**RE: ADEQUACY REVIEW - PROPOSED WAREHOUSE AND LOGISTICS HUB - SSD-17647189**

**PROPERTY AT 884-928 MAMRE ROAD, KEMPS CREEK (LOTS 52 AND 53 DP259135)**

**Adequacy Review**

TABLE 1 DPIE Adequacy review																	
DPIE Adequacy Review Comments	Formalised Response																
<ul style="list-style-type: none"> <li>• The description of the proposal is not clear or consistent. Amend the description of the development in Section 3.2 of the EIS, any other sections of the EIS including the technical assessments to include all elements of the development including the following:                             <ul style="list-style-type: none"> <li>○ Details of the fitout and mechanical plant of the warehouse on proposed Lot 2 are not detailed in the EIS or Acoustic Report</li> </ul> </li> </ul>	<p><b>Section 3.2</b> of the EIS has been updated to address that the Proposal does not include the fitout of the warehouse. Internal fitout of the warehouse building will be subject to separate development approval (Development Application (DA) or Complying Development Certificate (CDC)).</p> <p>Details of the mechanical plant of the warehouse on Lot 2 are not available as mechanical plant

Drawing Title:
Landscape Section EE & Typical Details
DWG No:
LDA-08

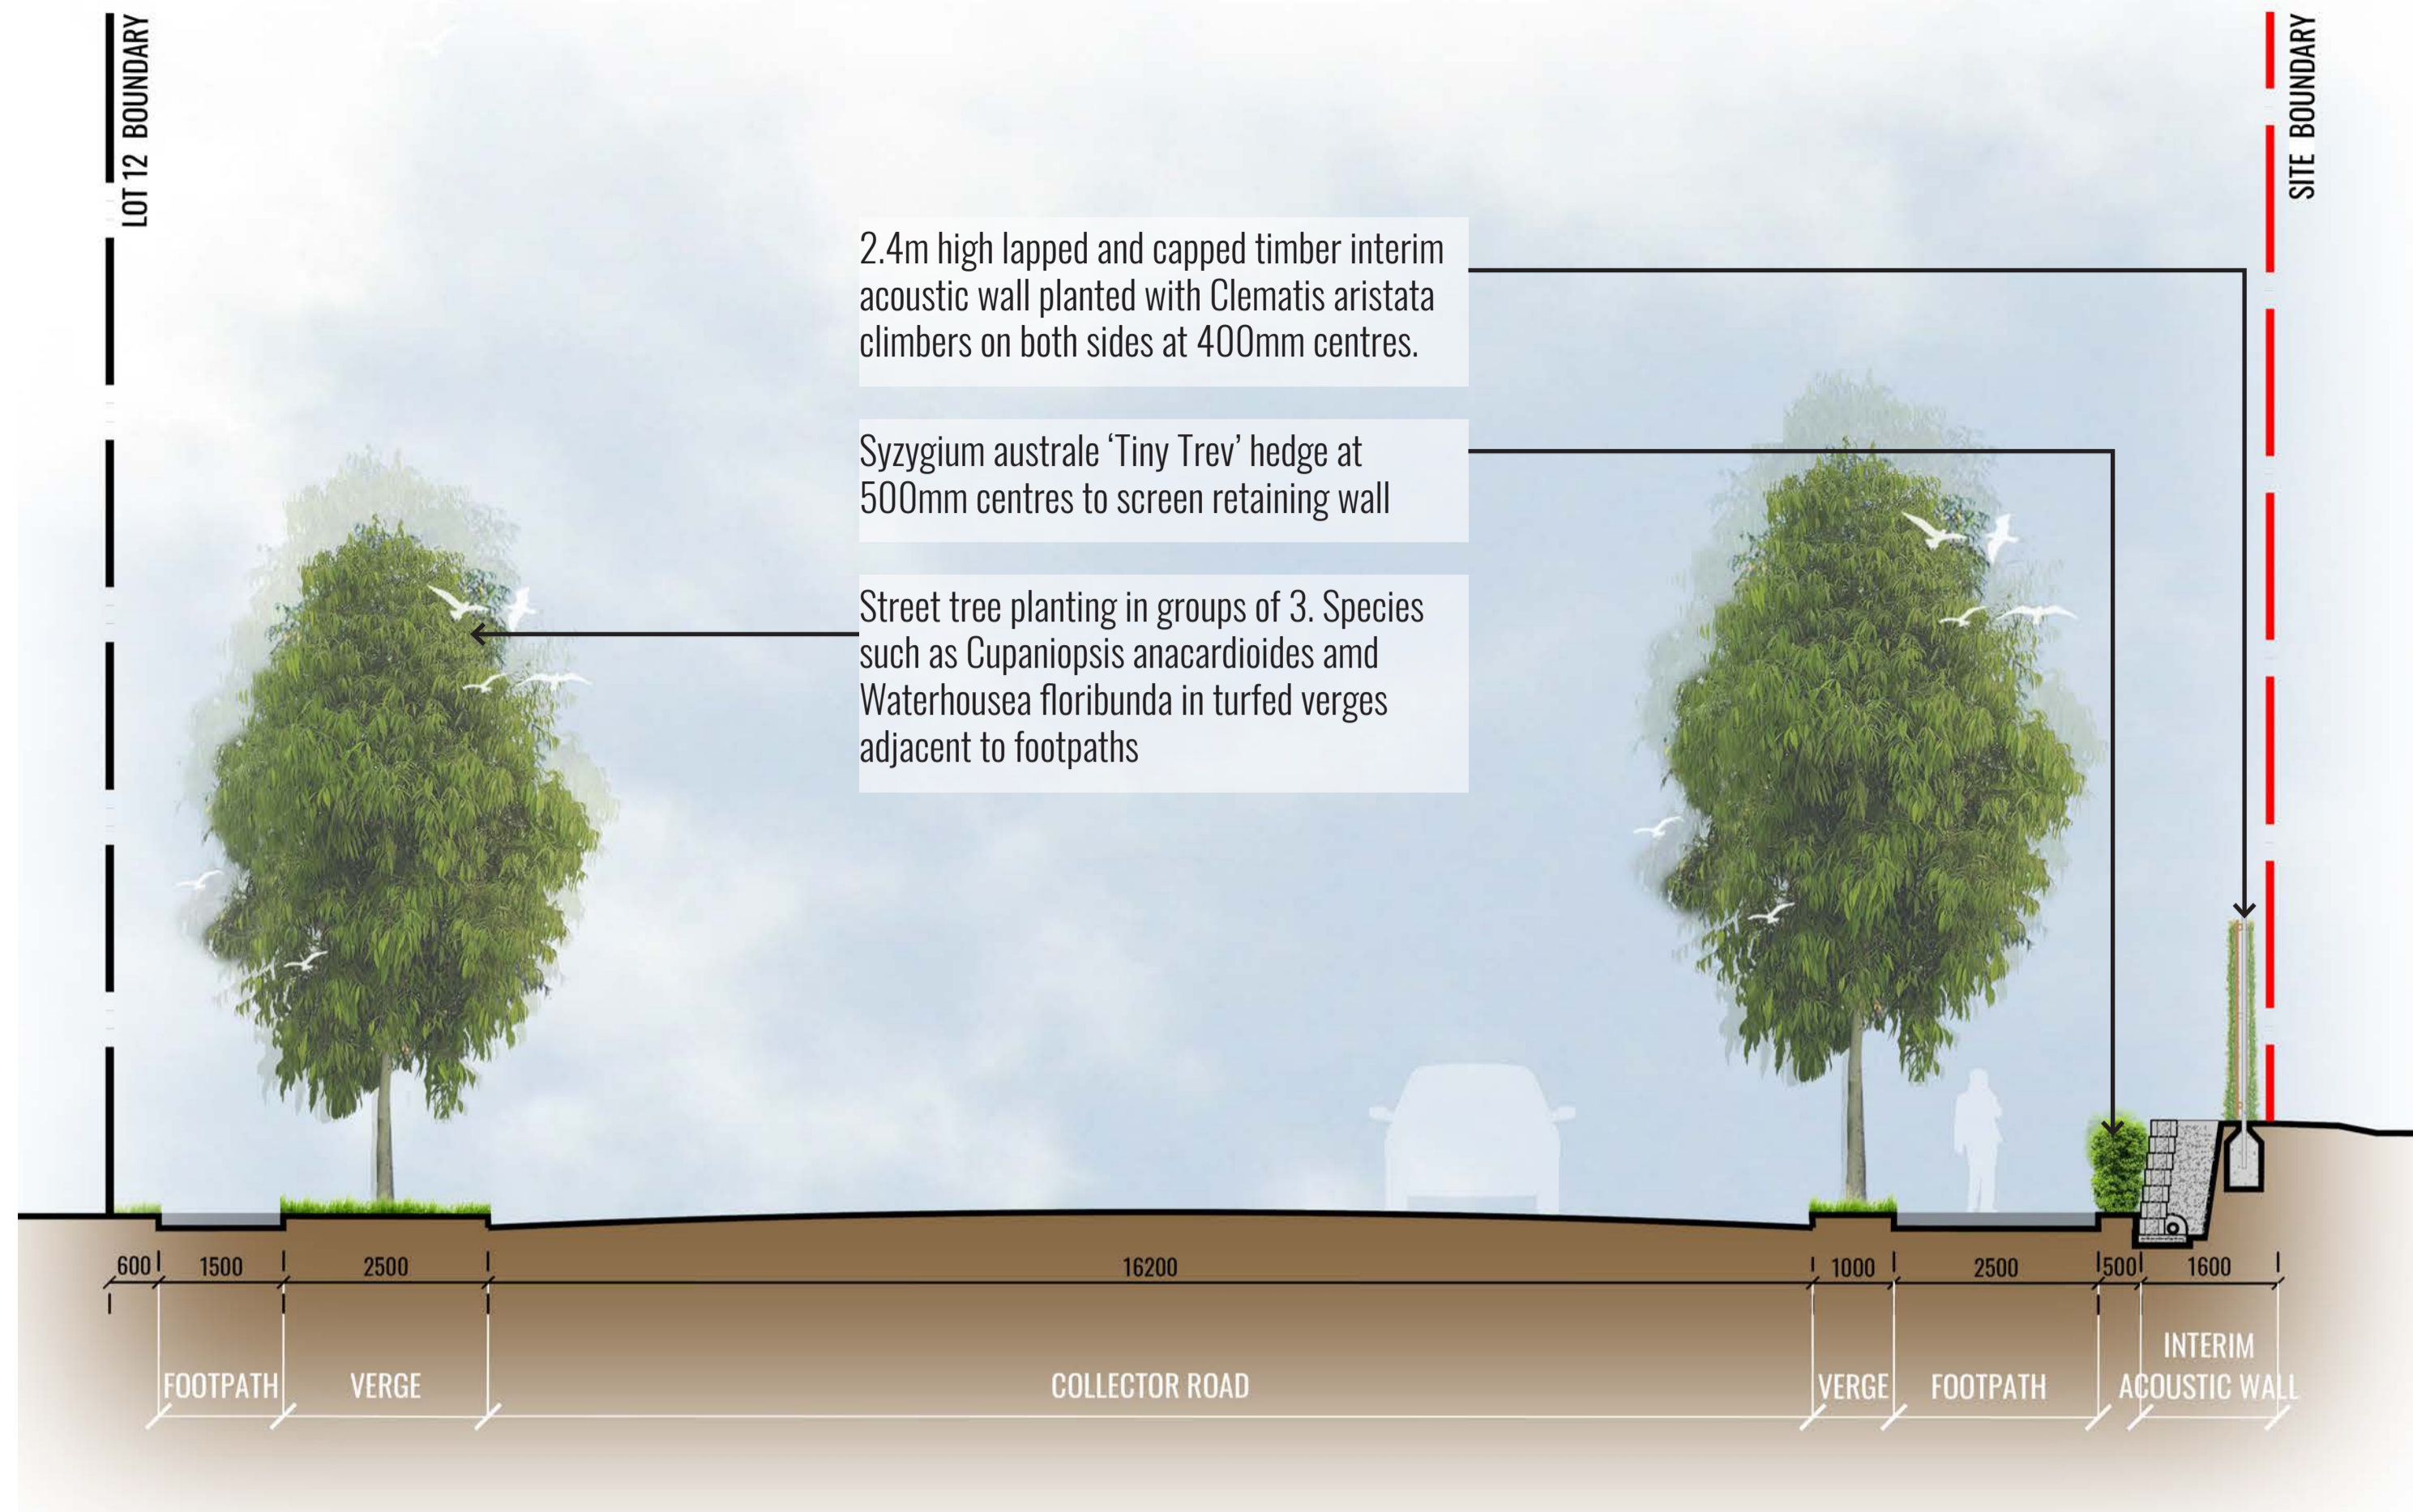
<p>technical assessments are to be amended to address the proposed building pads as these will establish the footprints for future development on the site.</p>	<p>outside of Lot 2 will be subject to separate development approval (DA or CDC).</p>
<ul style="list-style-type: none"> <li>The EIS is not clear on when the acoustic barriers will be installed and how long they are required on site. The EIS refer to the acoustic barriers as 'temporary'. However, Section 6.10.7.1 of the EIS states: <i>All acoustic barriers are only required while the residential dwelling at receivers 2 (residential dwelling at 930-966 Mamre Road to the south) is occupied.</i> Our review does not indicate an application for the redevelopment of this property has been made. As such, the categorisation of the acoustic barriers as 'temporary' is to be reconsidered. The EIS is also to be amended to detail when the acoustic barriers will be installed.</li> </ul>	<p>The acoustic barriers will be installed at the completion of Lot 2 construction works as an interim measure to mitigate the associated noise impacts and will be removed in the future when the adjoining dwellings are no longer occupied. <b>Sections 3.2, 3.2.2</b> and <b>6.10</b> of the EIS have been updated to reiterate the interim nature of the acoustic barriers.</p> <p>As illustrated in the Estate Landscape Plans (<b>Appendix 7</b>), it is noted that the interim acoustic barrier will be planted with Clematis aristate climbers on both sides at 400mm centres, mitigating visual impacts from the adjoining properties to the south and south west.</p> <p>Street tree planting will also be planted along the Site's southern boundary in turfed verges adjacent to footpaths to mitigate the visual impact of the development.</p> <p><b>Sections 3.2.2, 3.2.7</b> and <b>6.3.1</b> of the EIS have been updated to demonstrate screening will be provided for the interim acoustic barriers.</p>
